CITY OF ALBUQUERQUE

June 21, 2021

**Re: Kraemer Fields – 2812 Karsten Ct. SE
Erosion and Sediment Control Plan
Engineer's Stamp Date 6/10/2021 (M14E012A)**

**KRAEMER FIELDS**  
2811 KARSTEN CT SE, ALBUQUERQUE, NM 87102  
**LANDSCAPE PLAN**

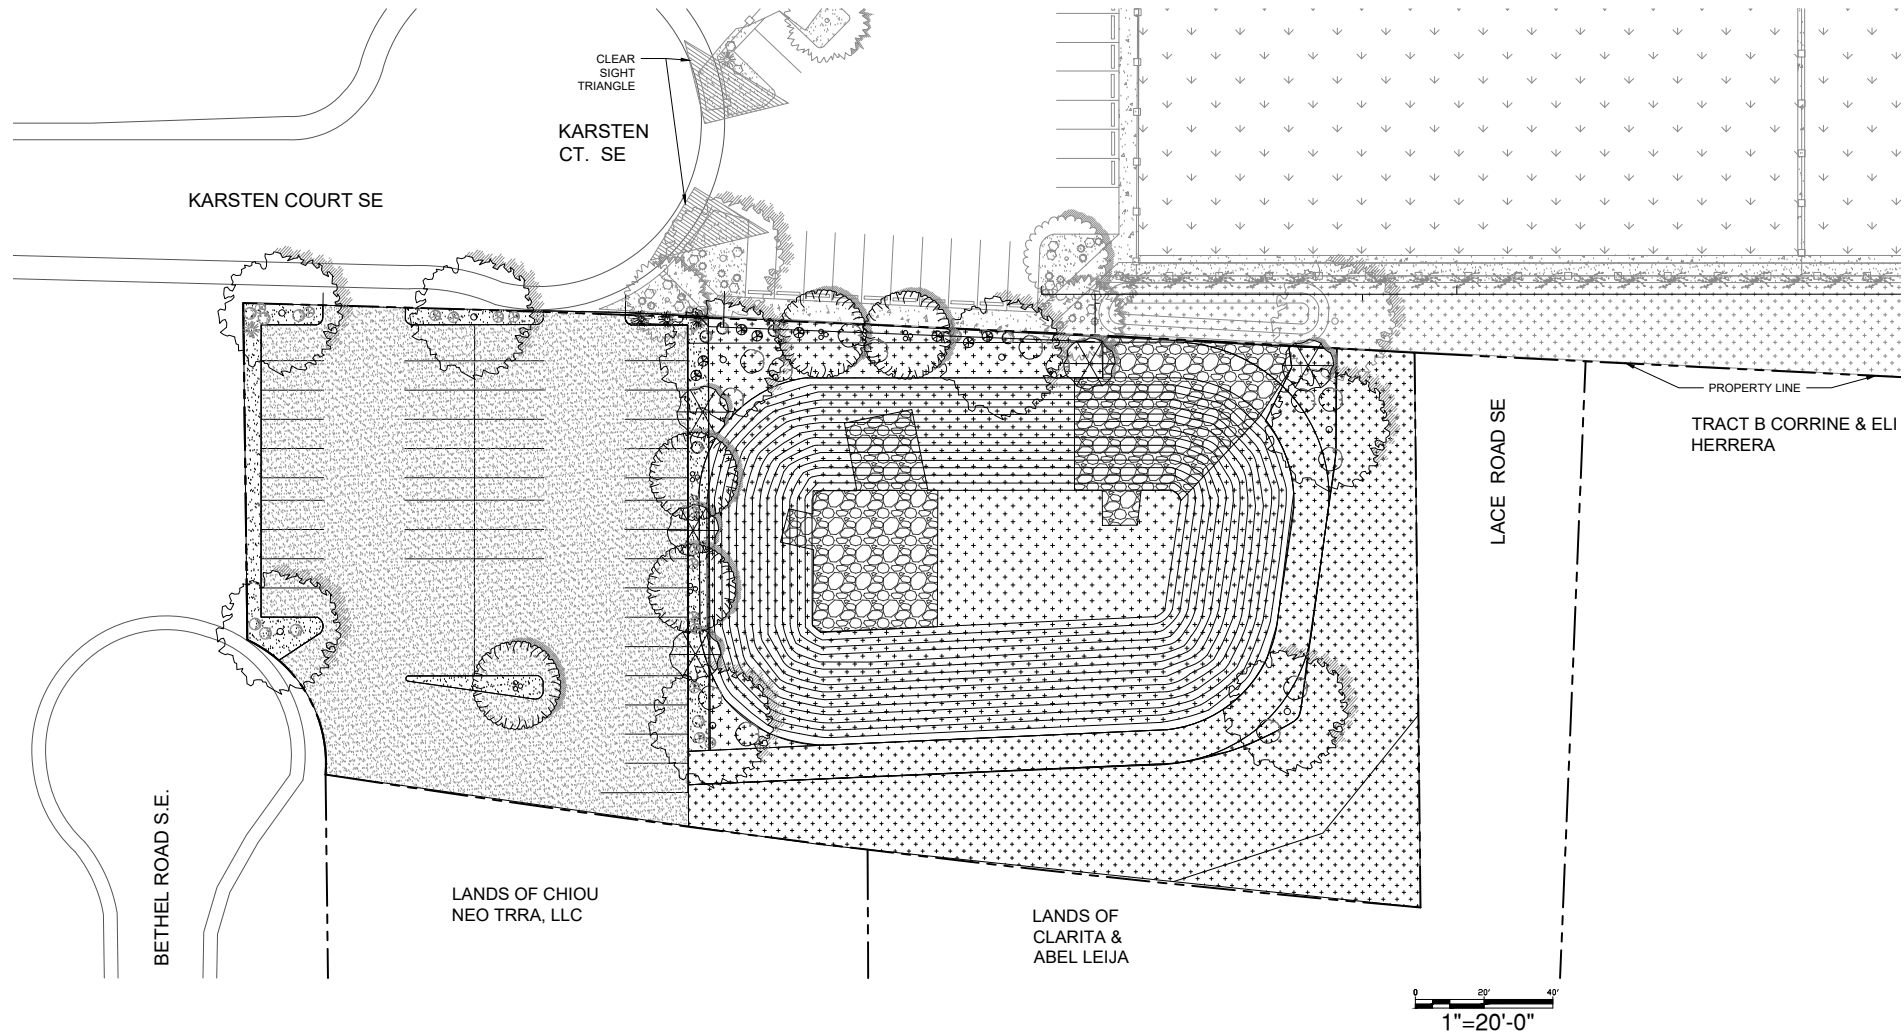
Based upon the information provided in your submittal received 6/10/21 the above referenced plan is approved to be included in the SWPPP, the Building Permit plans, and the Work Order plans with the condition Aggregate Mulch be used instead of Hydromulch on the pond and steep slopes or equal per the EPA's Final Stabilization Criteria.
